PCD File # PPR2227

LANDSCAPE PLAN

Client:	CD BENT GRASS LLC
Address:	106 S. KYRENE RD. CHANDLER, AZ 85226
Phone:	PHONE: A.TTN: B. HAYENGA
Date:	03/22/22
Revised:	09/30/22
Initial Submittal:	
Revised Per County Comments:	
NO.:	1
DESCRIPTION:	REVISED PER COUNTY COMMENTS
W.C. CIVIL:	7220 W. JEFFERSON AVE STE. 204 LAKEWOOD, CO 80235 PHONE: (303) 390-0172
WC CIVIL:	
FINAL LANDSCAPE PLAN	
DUNKIN BENT GRASS	
SITE DEVELOPMENT PLAN	
LOT 1A, BENT GRASS EAST COMMERCIAL FILING NO. 2A,	
LOCATED IN TOWN OF PEYTON,	
COUNTY OF EL PASO, STATE OF COLORADO	
File:	
WC Civil Team:	TS, LP
Date:	2022/10/20
Engineering No.:	AS NOTED
Scale:	
Sheet No.:	9

Landscape Plan Drawings_V2.pdf Markup Summary

LANDSCAPE PLAN

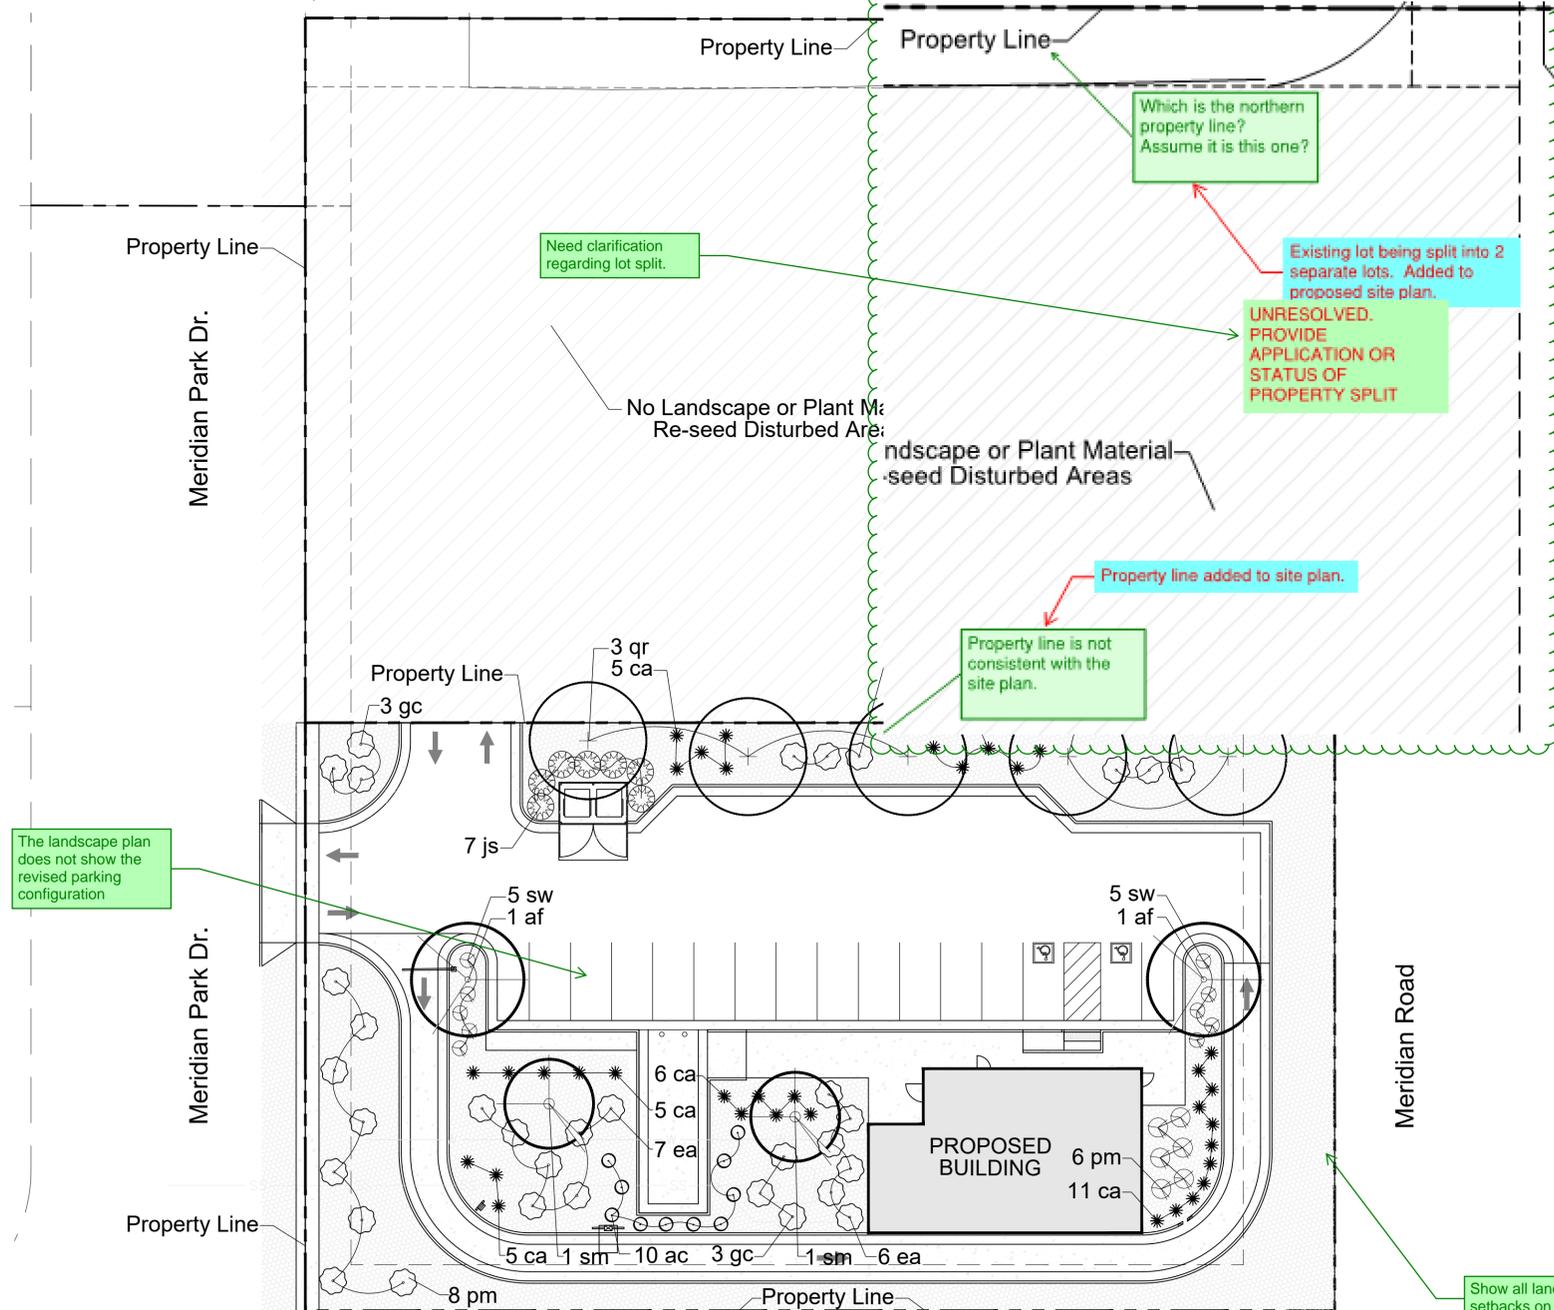
Please see comments on Landscape Plan provided in the Site Development Plan set V2. Please make sure the correct plan is incorporated into that set, or remove from the set.
